October 2, 2015

Project Name: 3-unit condominium building
Project ID: 2015-121
Address: 72 Munjoy Street CBL: 16-B-08 and 09
Applicant: Robert LeBlanc
Planner: Nell Donaldson

3-unit Condominium Development
68-72 Munjoy Street
Level III Site Plan and Subdivision Review
2015-121
Peninsula Property Development

Submitted to: Portland Planning Board Date: September 24, 2015 Public Hearing Date: September 29, 2015	Prepared by: Nell Donaldson, Planner CBLs: 016-B-009 Project #: 2015-121
--	--

PM feet
Width : 6.99
Track : 6.00
Lock to Lock Time : 6.0
Steering Angle : 31.6

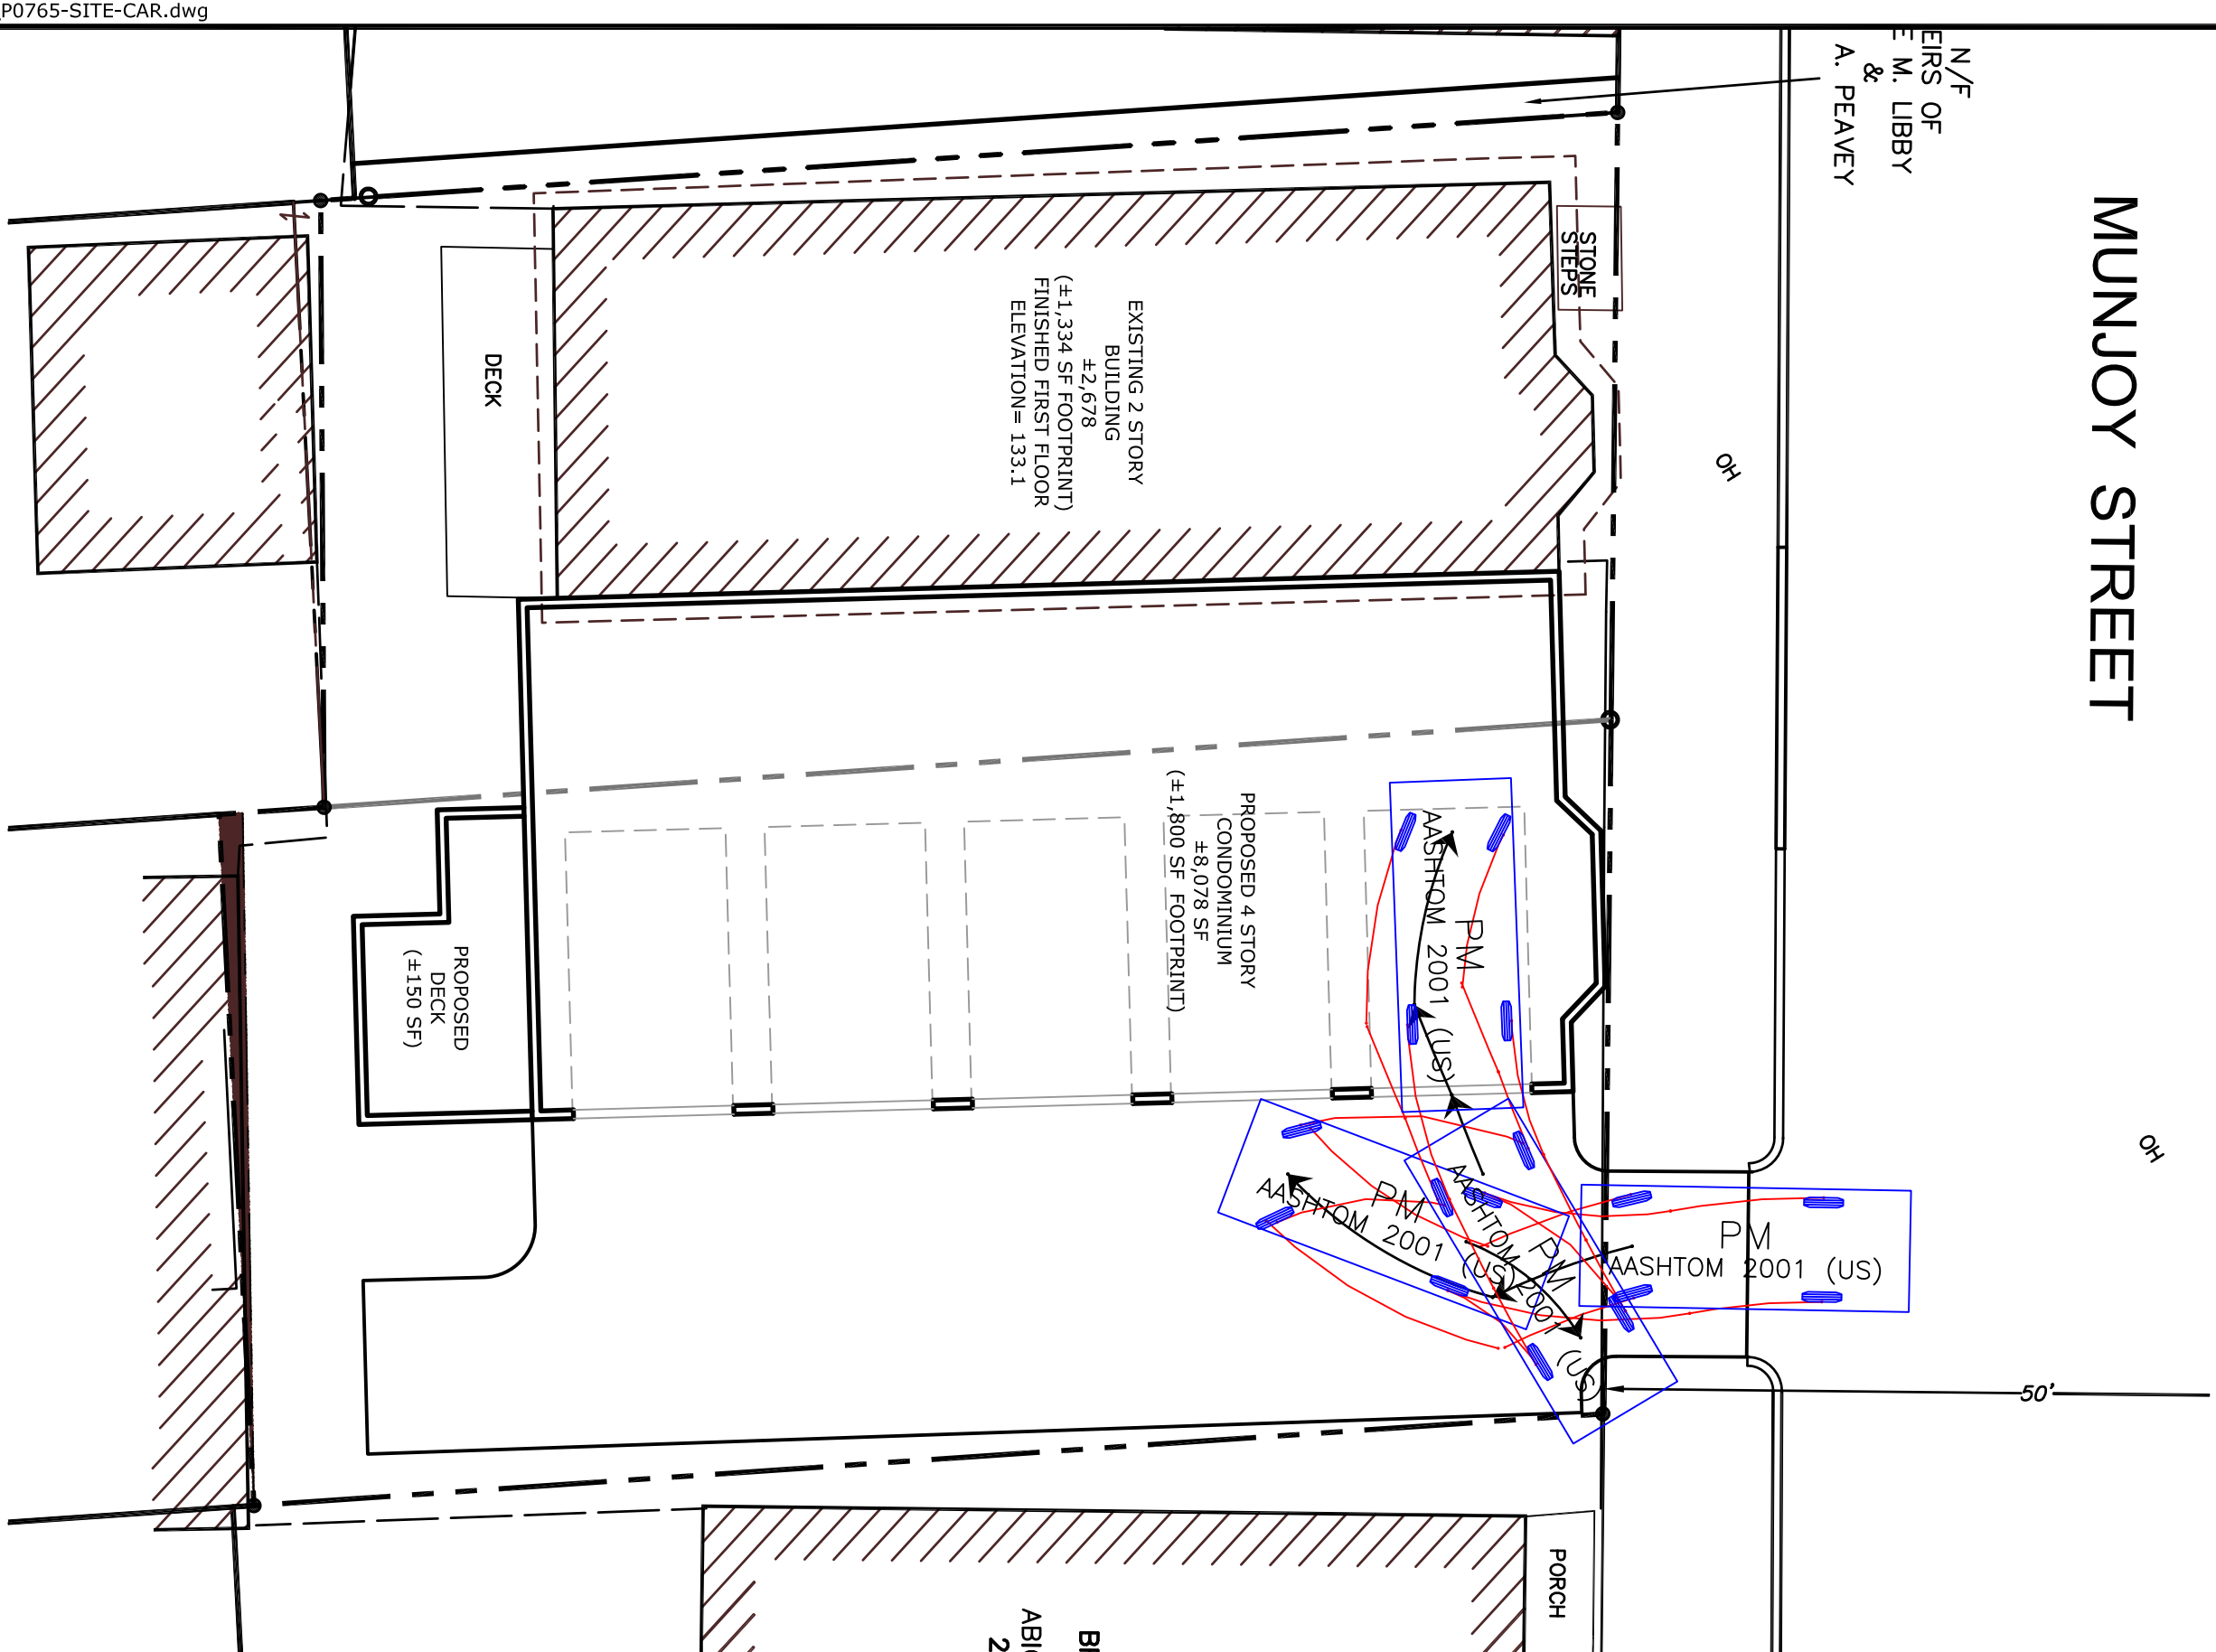
The final plans include the reconstruction of existing brick sidewalk and apron along the frontage of the site. The plans also include a new porous concrete drive aisle which will provide access to five parking spaces within the first floor of the proposed building. The plans show this aisle measuring 18.5' in width and touching the southerly property line at the site's southeast corner. The applicant has provided a turning template which shows that vehicles can maneuver in this area. Mr. Errico writes,

I have reviewed the project site plan and vehicle turning template information and generally find the project to be acceptable. Based upon the vehicle template graphics provided, vehicles will be able to access and egress the parking garages - but with great difficulty. I'm supportive of a waiver on the width of the parking aisle, but the site plan shall be revised to install a barrier that prevents vehicles from encroaching on the abutting property. One suggestion would be a wooden guide rail.

1. Prior to the issuance of a certificate of occupancy, the applicant shall submit plans to eliminate the potential for vehicular encroachment on the adjacent property for review and approval by the city's consulting traffic engineer;
2. The applicant shall provide a revised landscaping plan including:
 - a. Plant quantities, sizes, and locations;
 - b. Details regarding the supporting structure for the proposed climbing hydrangea; and
 - c. Notes which state measures to be taken to protect street trees during construction for review and approval by the city's arborist; and
3. The applicant shall revise the plans to depict underground electrical service for review and approval by the Department of Public Services.

The applicant has engaged the adjacent neighbor in an effort to come to an agreement on the treatment of this property line. Resolution of this matter has been included as a condition of approval.
